**KIRKLEES METROPOLITAN COUNCIL
INVESTMENT & REGENERATION SERVICE**

Reference No:	2023/62/90630/W
Site Address:	53, Greenhead Road, Huddersfield, HD1 4ER
Description:	Erection of two storey extension
Recommending Officer:	Tom Hunt

DECISION – REFUSED

Officer Report

West Elevation
1 : 50

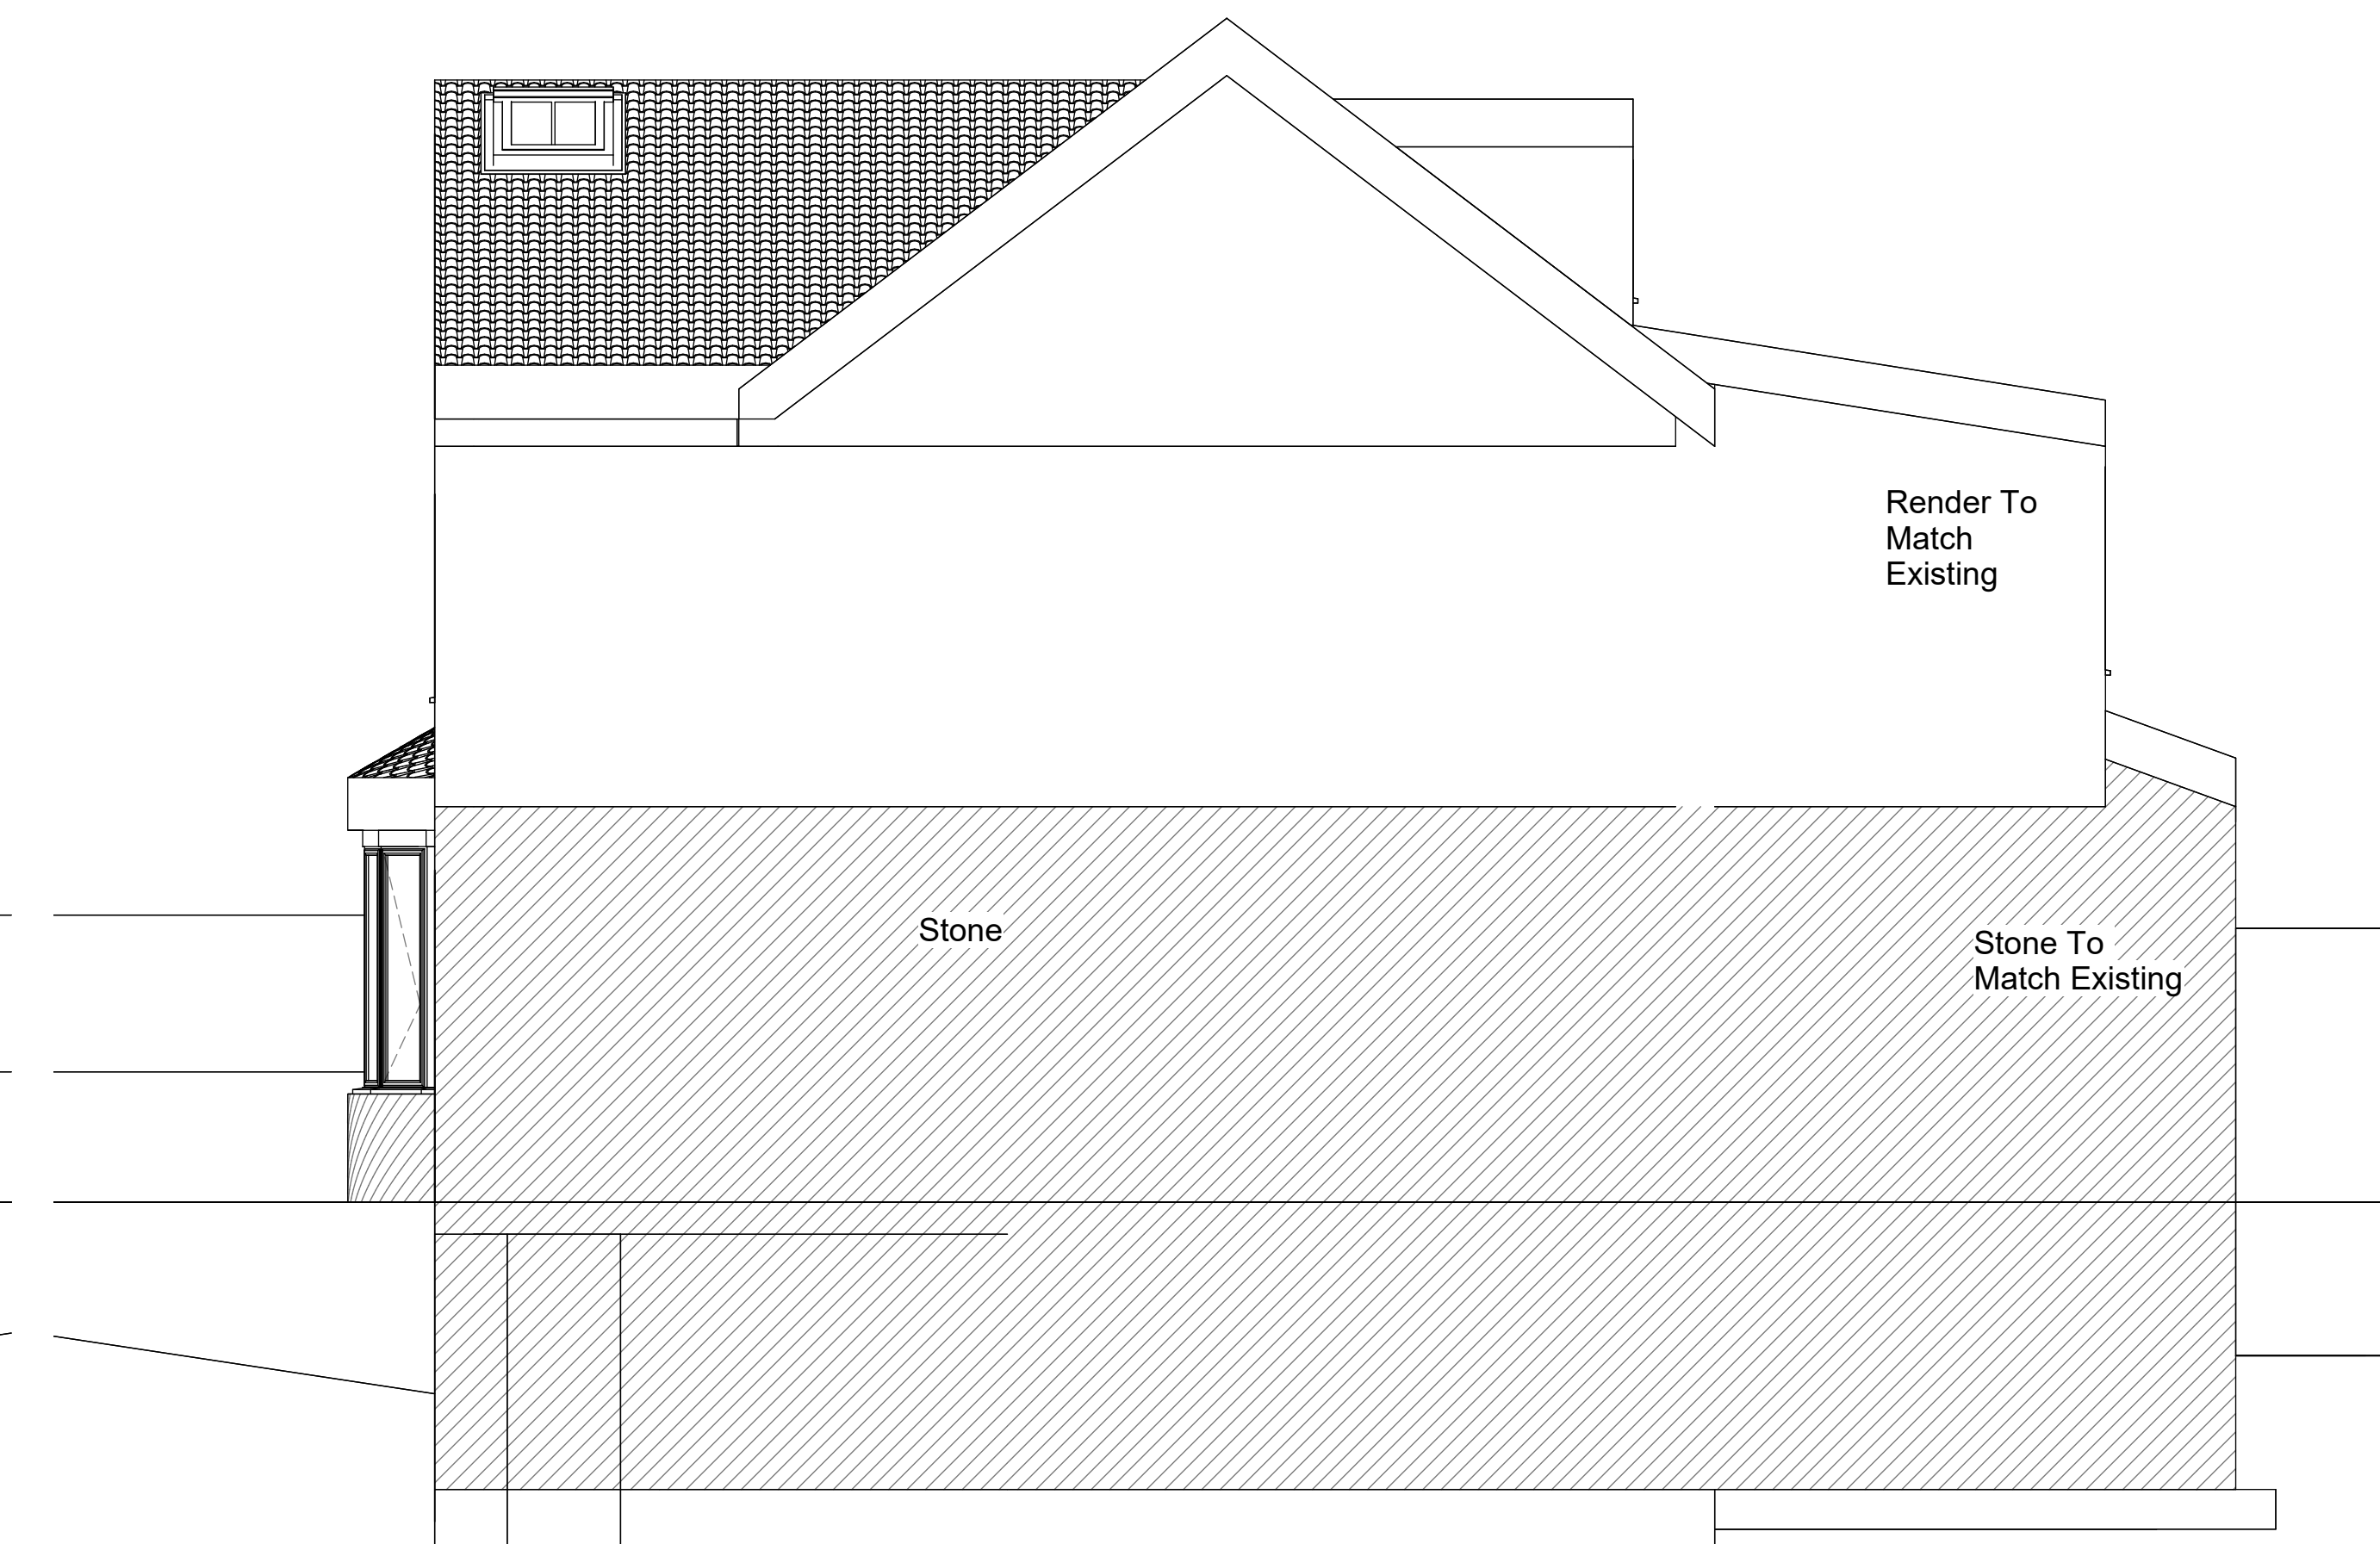
Officer Note: Existing elevation plans do not show the full extent of the gable end front feature and the proposed elevation does not definitively set out the proposed height of the rear raised area with steps.

Considering the impact on visual amenity that had not already been outlined in the above, the proposed dominant design of the tiered two-storey extension would fail to achieve a subservient or sympathetically integrated design to the original host. The proposal would project 4m from the rear at ground and then project 3m at first floor level with a solid understorey base increasing its bulk and massing. It would be closely set onto the southwest shared boundary and set 1.2m back from the northeast boundary with eaves far exceeding a height of 3m failing to offer a 1.5m property gap to boundary increasing its visual dominance and oppressive appearance. Neighbouring houses have not been extended similarly in order to reduce its effects and despite the presence of greenery to the shared boundary, the proposal would not be adequately screened by the greenery of insufficient height.

The tiered design would appear as a cramped and dominant design within its tight plot unduly contrasting with its neighbours with its roofs appearing in pitch and form to be incongruous to the host, its neighbouring properties and others in the locality.

Cumulatively the proposed development would not present a subordinate addition. They would present an undue level of bulk and massing to the host obscuring the original design of the host and to have roofs failing to integrate with the scale and massing of the host's own roof. It would thus fail to respect the original design and character of the host property eroding the character and setting of its locality.
